Development Control
Ribbles Valley Borough Council

App no: 23.0739

Address: Land off Elker Lane Billington

Proposal: Outline application for the development of a Class C2 Continuing Care retirement community.

SITE LOCATION PLAN

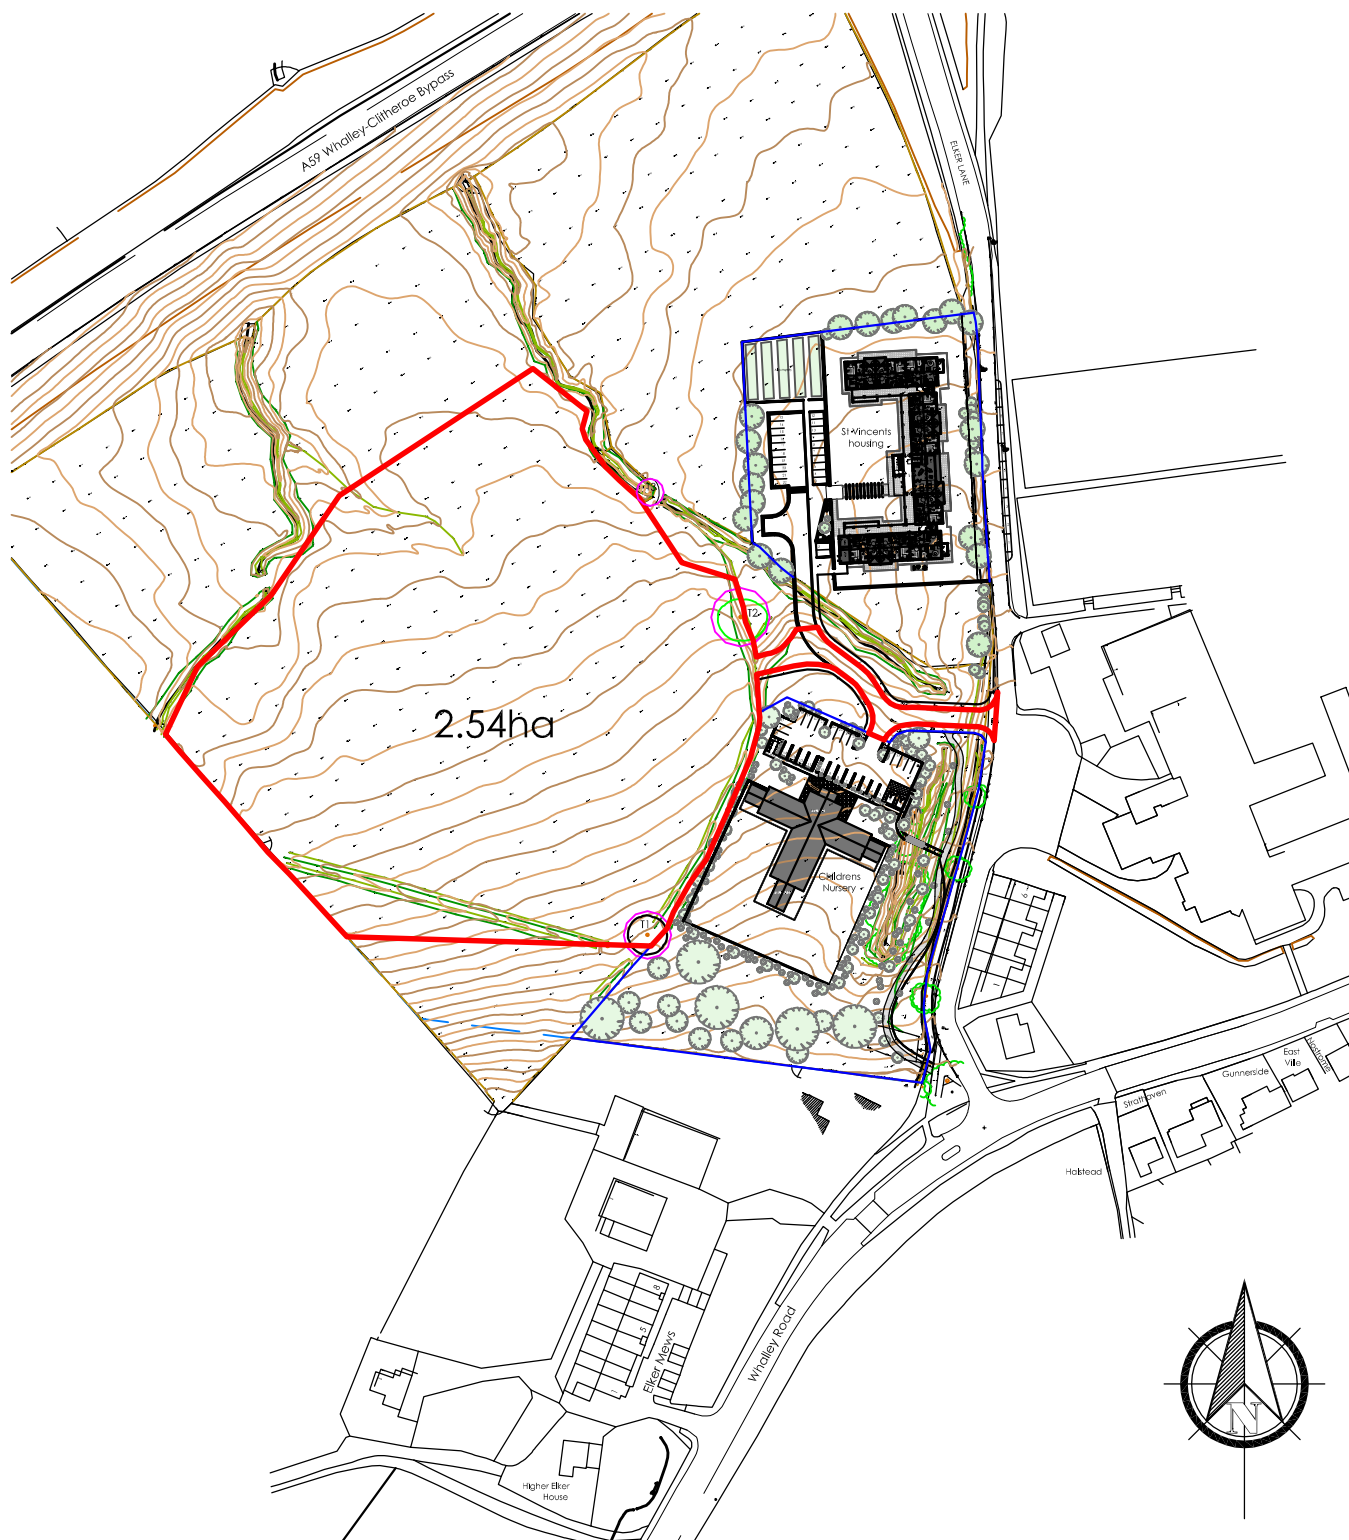
The location plan shows the carriageway of Elker Meadows within the red edge. However it does not clearly show the blue edge and the applicant should confirm that they have a right of access over Elker Meadows if they do not own the land. There is draft Section 38 agreement for Lancashire County Council to formally adopt Elker Meadow however this is not yet signed so there is no legal agreement in place to provide certainty that this will become public highway.

The new linking footway between the site and Whalley Road, which was conditioned on the outline application (Condition 15 - 16/0927), is not within the red edge. The line of the path is likely to require an amendment due to the watercourse where it is culverted under Elker Meadows. We would request that a condition is stated to allow details to be submitted at a later date.
